SCOPING OPINION:

Proposed Teddington Direct River Abstraction

Case Reference: WA010006

20 November 2024

Title: PLAN 2.1 – ENVIRONMENTAL CONSTRAINTS PLAN - PHI SHEET 3 OF 4

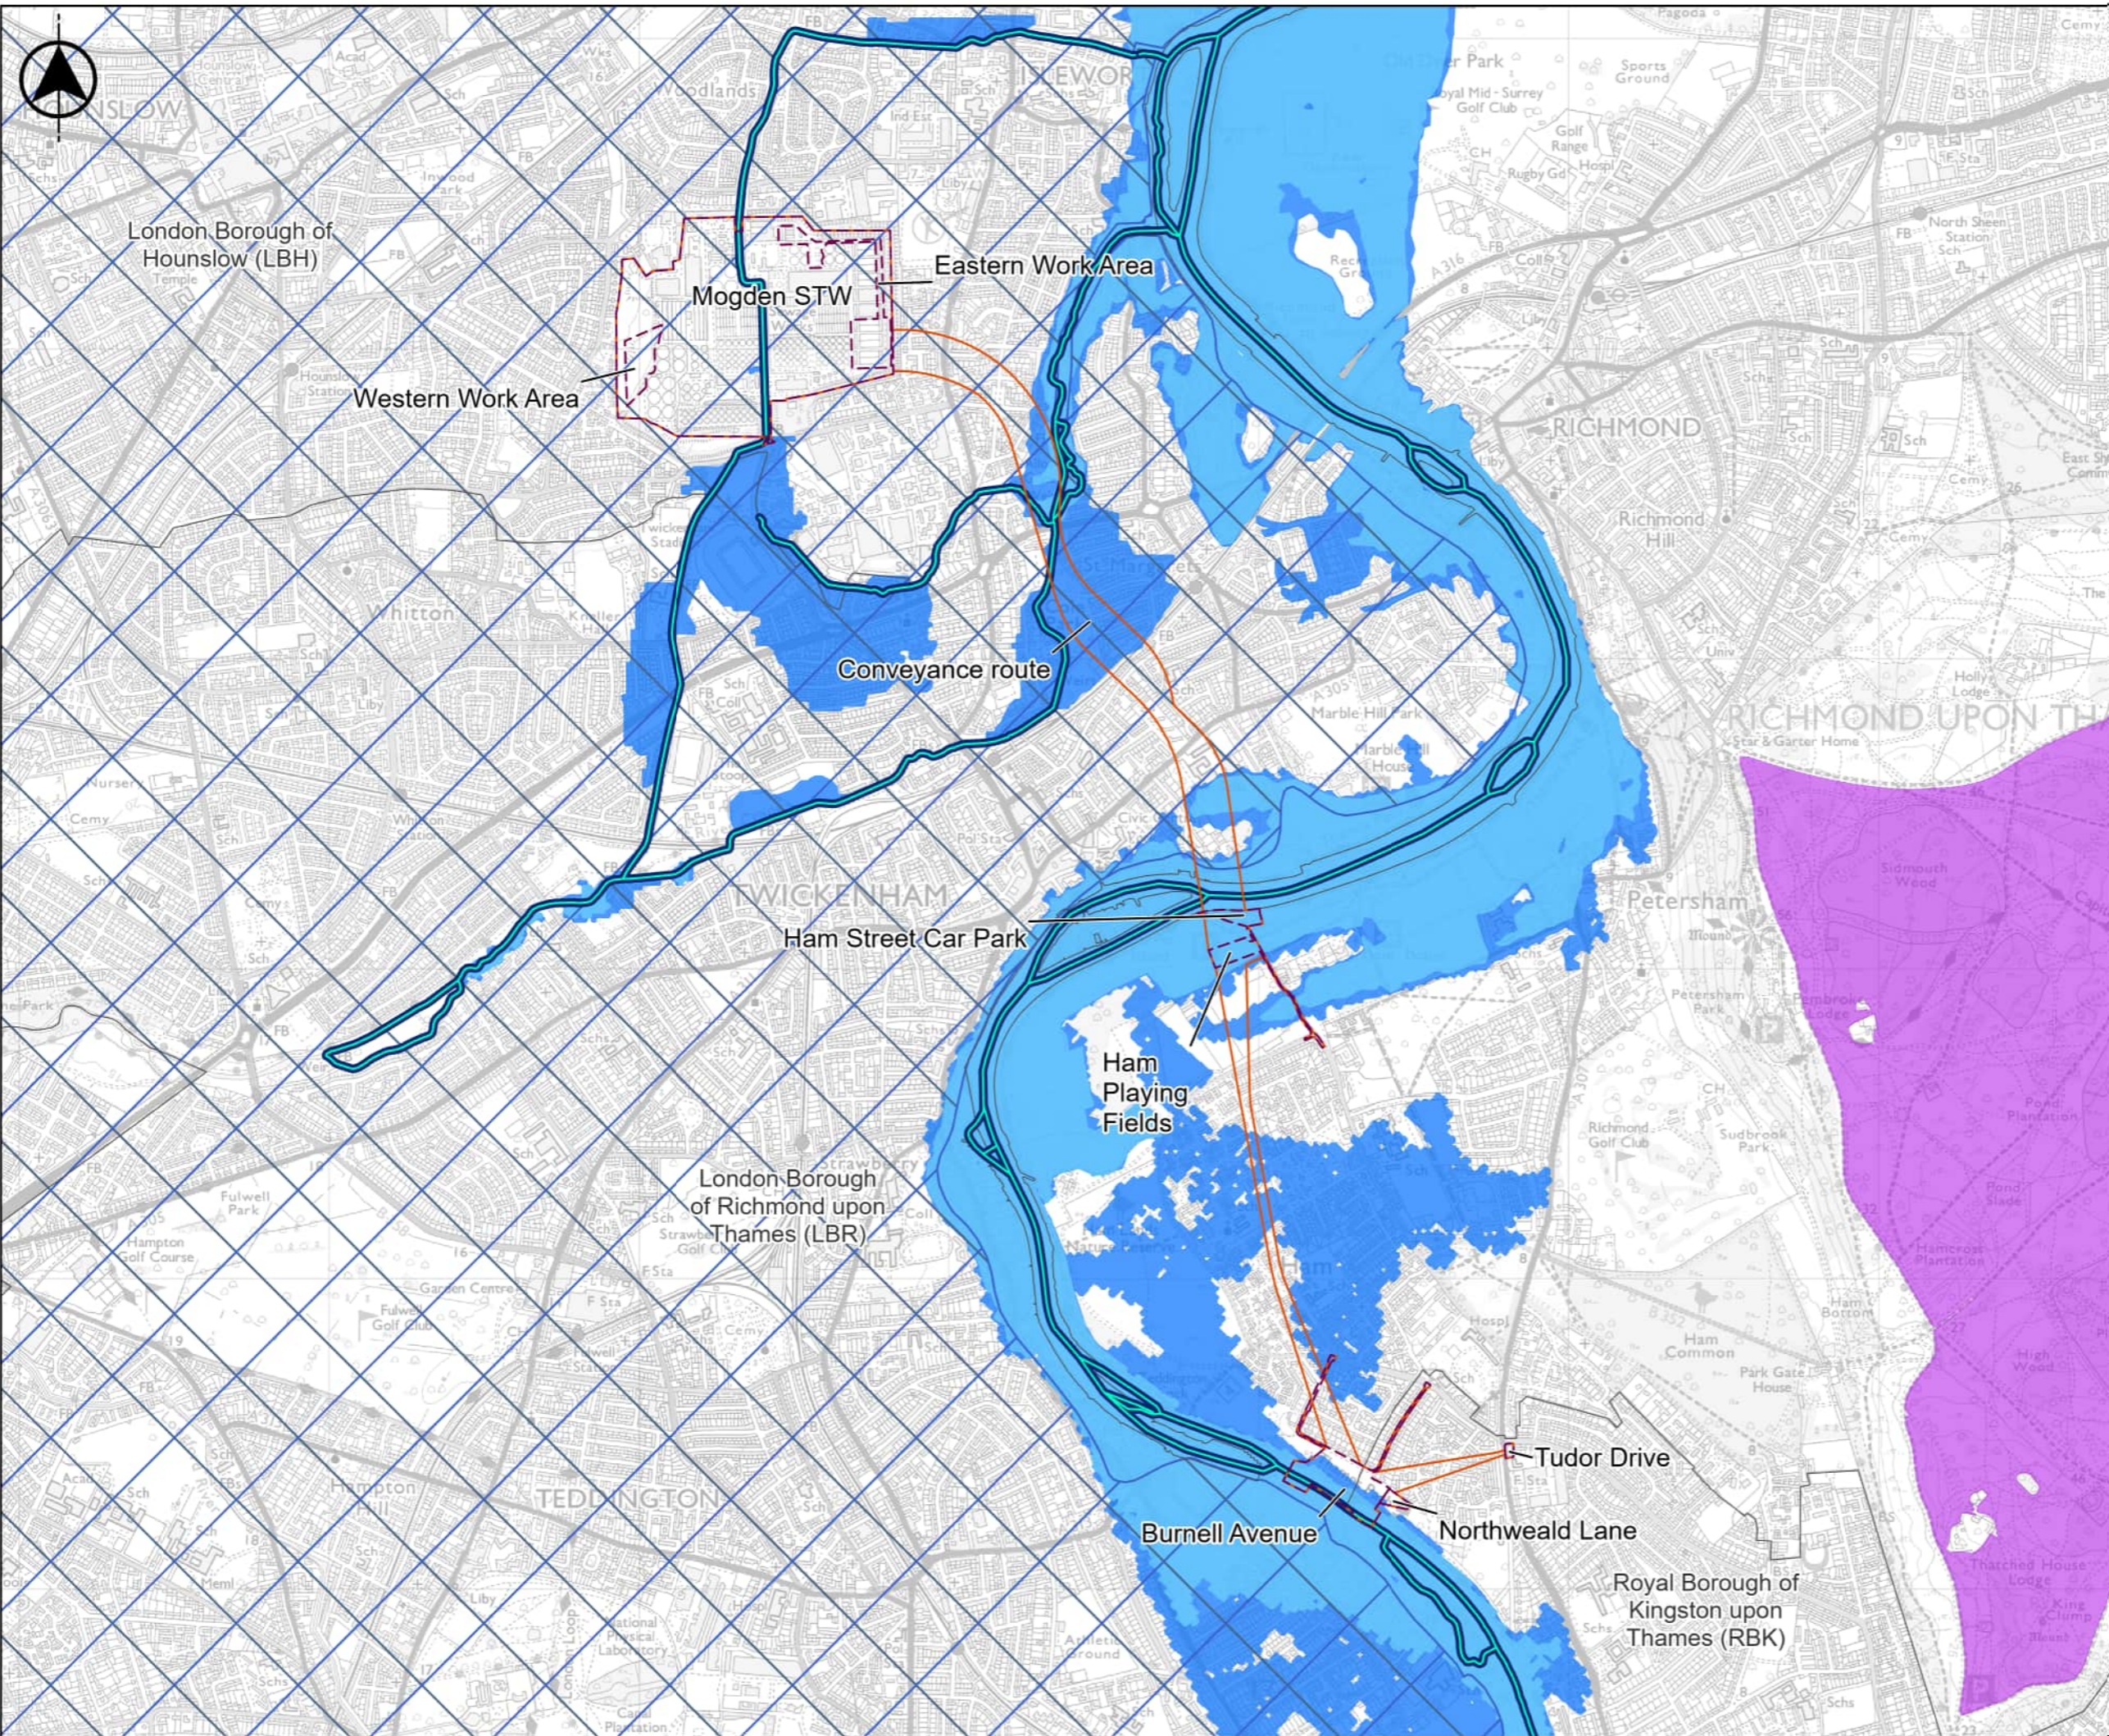
33.17	Plans 2.1 and 8.1 (Appendix A)	Figures	Figures in the ES should include labelling of heritage assets to aid understanding.
33.18	n/a	Non-designated above ground heritage assets	The ES should confirm if there are any non-designated or locally listed buildings within the study area and indicate their location on a plan. Where significant effects are likely to any assets identified, these should be assessed in the ES. The Applicant's attention is drawn to the comments of Historic England and London Borough of Richmond upon Thames (Appendix 2 of this Opinion).
